From: Simon Davis
Sent: 12 October 2021 15:11
To: Havis, Sean [REDACTED]
Cc: Sparkes, Jessica [REDACTED]
Subject: Drove Lane Sales Cabin refs Y/141/21/PL and Y/142/21/A

Drawing Title:
SALES AREAS 01

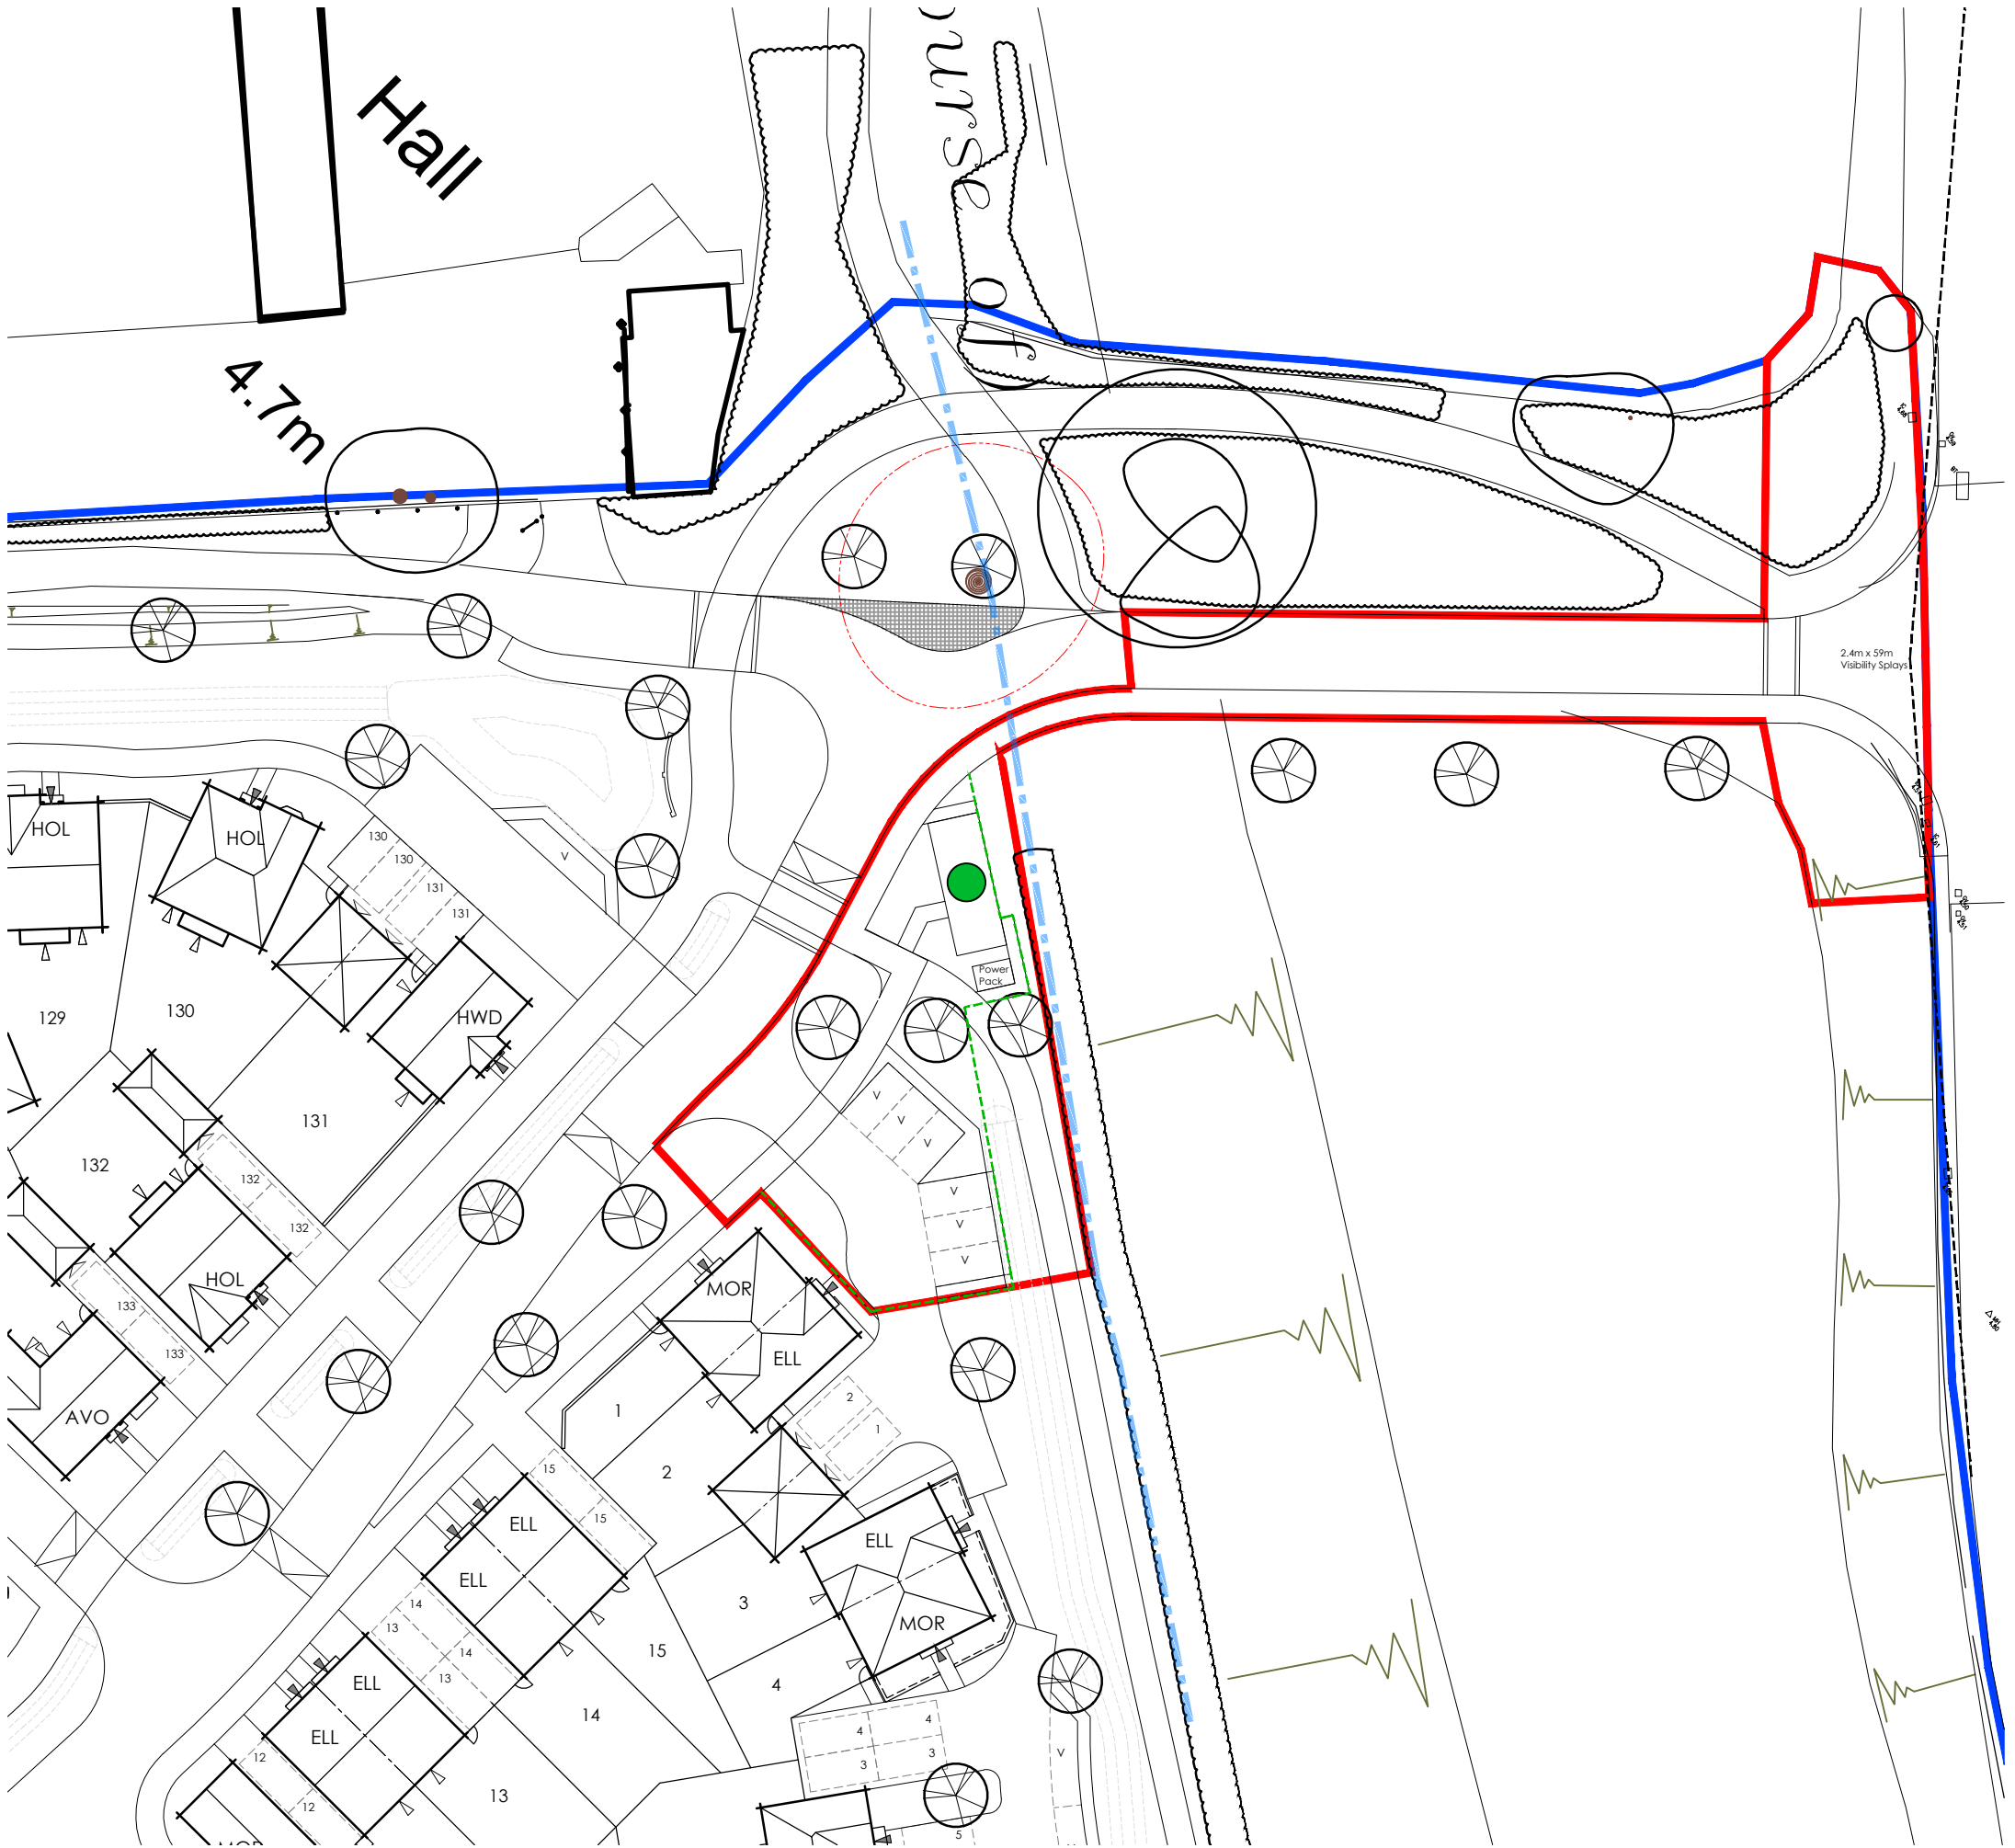
WSCC PRoW state that *"On closer inspection of the Sales Areas (Block Plan) rather than the Location Plan I originally looked at, it is unclear if it is actually sited on FP200_1. Could you please ask the applicant to show the position of the nearby footpaths on a plan so I can see more clearly?"* Please provide a plan.

WSCC Highways state that: *"With regards to the proposed advertising the applicant should demonstrate that the totem and static banner flag poles, adjacent to the site access, are located outside of the visibility splays for the main access onto Main Road. If the advertising is located outside of the visibility splay the Highway Authority would not have any objections to the proposals."* Please demonstrate this with a drawing.
